Submission for Job: #6011 SSD 6011 - Mixed use residential development within the South West Plot

Site: #2825 SICEEP Site, The Haymarket; Darling Drive, Sydney

SSD 6011 - Mixed use residential development within the South West Plot

## Winter Solstice (21<sup>st</sup> June)

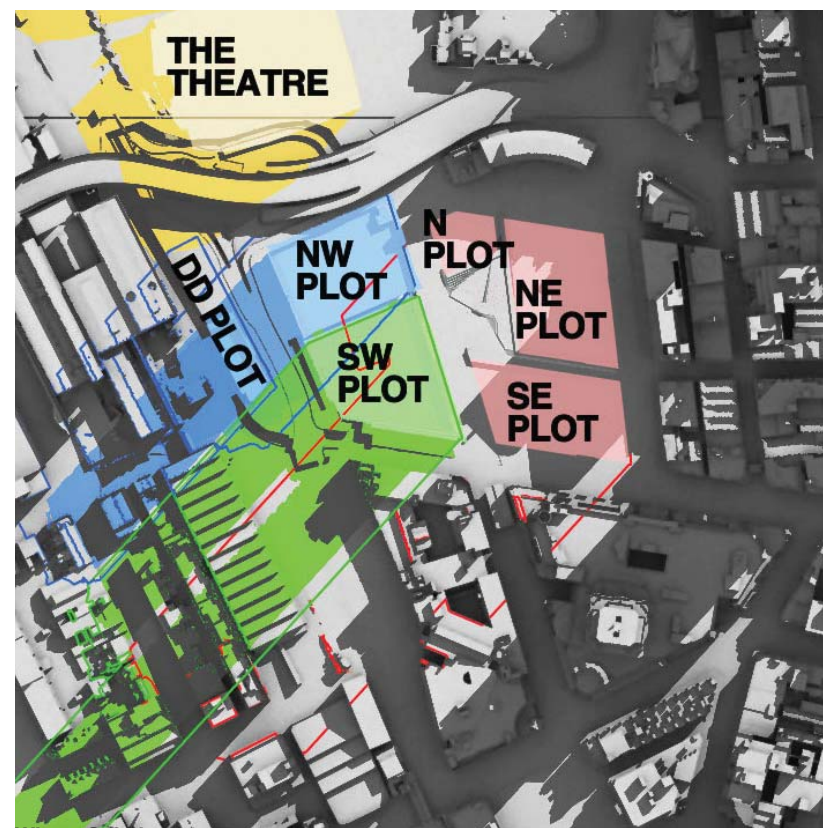
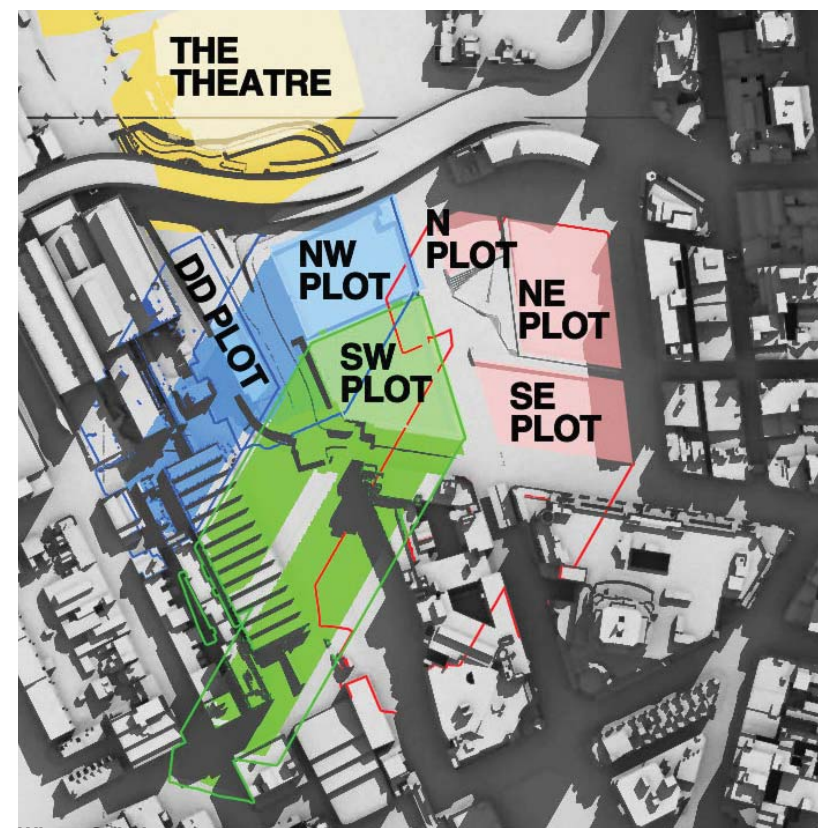
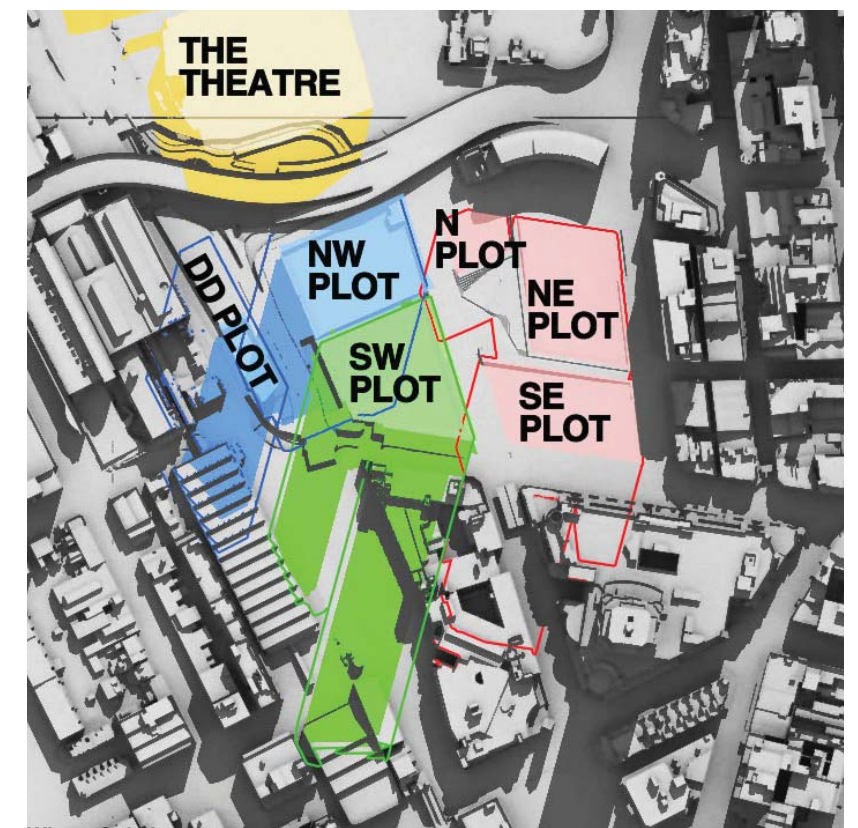
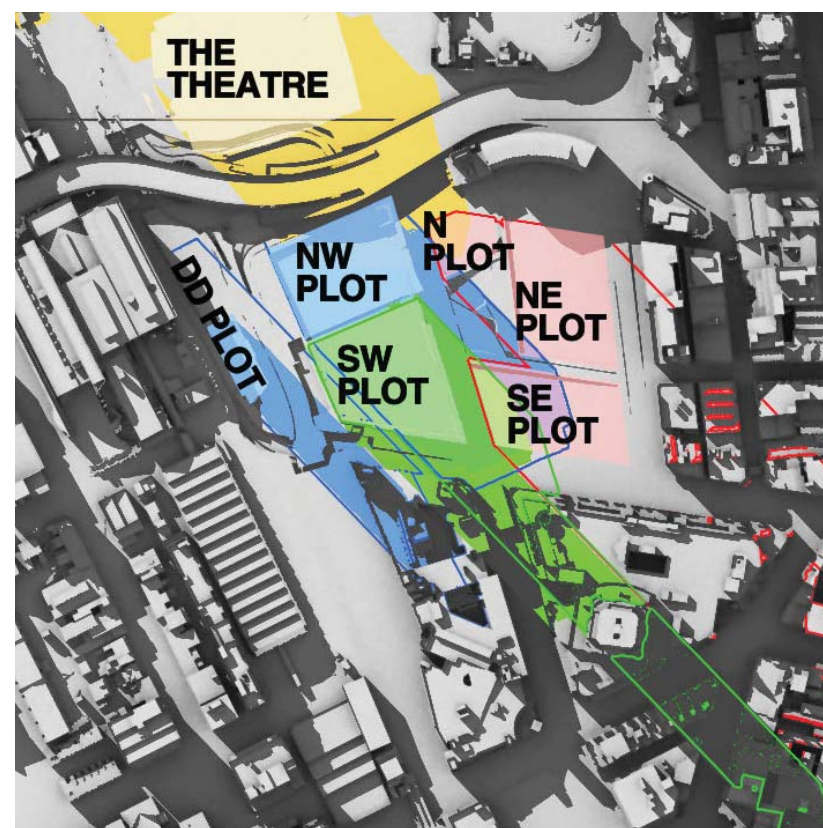
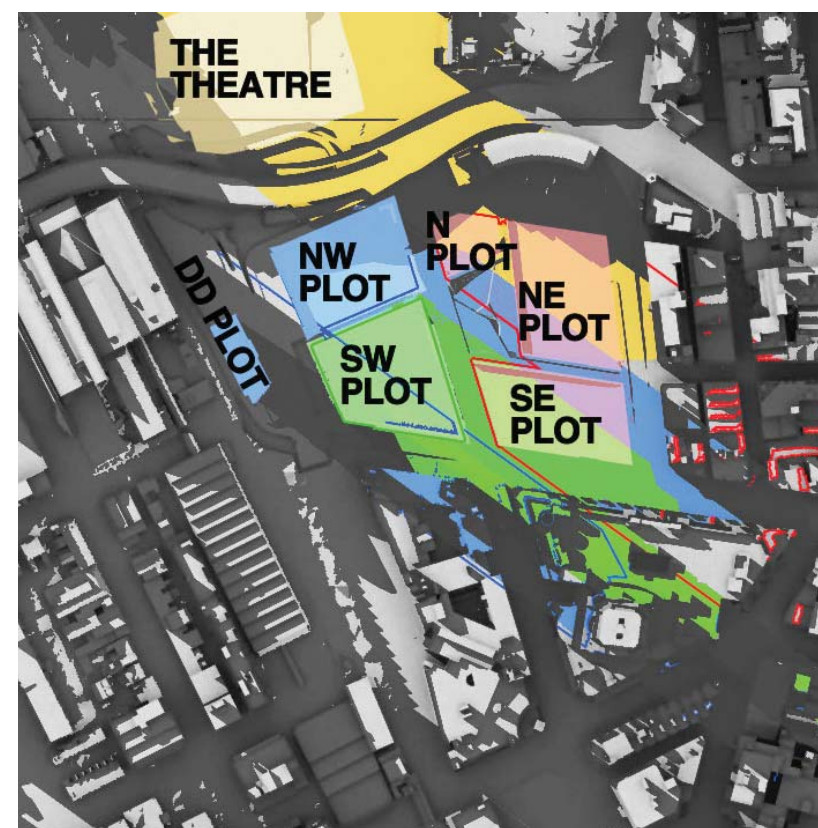
At 9am, 10am and 11am the west façade is totally in shadow due to other parts of The Peak building itself.

At 12pm there is still substantial existing shadowing on the west façade caused by the irregular shape of the west facade.

At 1pm the existing shadowing has been substantially removed, but not totally removed.

It can be concluded that some single aspect apartments on the west façade and some south-west dual aspect corner apartments currently receive less than 2 hours direct sunlight to habitable rooms and 50% of the private open space between 9am and 3pm on 21 June.

By 2pm the existing shadowing has been totally removed, but that is too late to achieve two hours of direct sunlight before 3pm.

At 9am, 10am and 11am the west façade is totally in shadow due to other parts of The Peak building itself.

At 12pm there is still substantial existing shadowing on the west façade caused by the irregular shape of the west facade.

At 1pm the existing shadowing has been substantially, although not entirely, removed. However, overshadowing of lower levels of the west façade by the concept proposal parameter plan shadows for the N,NE and SE plots has already started.

By 2pm the existing shadowing has been totally removed. However, overshadowing of the west façade by the SSDA4 and SSDA5 buildings has appeared and risen further up the west façade than the concept proposal parameter plan shadows for the N,NE and SE plots, which is still present.

At 3pm, the proponent states correctly that 45-45% of the western façade is overshadowed by the SSDA4 and SSDA5 buildings.

It can be concluded that, as a result of combination of the proposed development with existing shadowing of the west façade, some single aspect apartments on the west façade and the south-west dual aspect corner apartments which currently receive less than 2 hours direct sunlight to habitable rooms and 50% of the private open space between 9am and 3pm on 21 June will suffer additional overshadowing. It is beyond our skills to count the number of such apartments. We note that the proponent has made no attempt to do so.

Rather than counting the number of units which will not meet the DCP guidelines, the proponent attempts to trade-off direct sunlight at 4pm for lack of direct sunlight during the period 9am to 3pm. There is no provision in the DCP guidelines for such a trade-off.
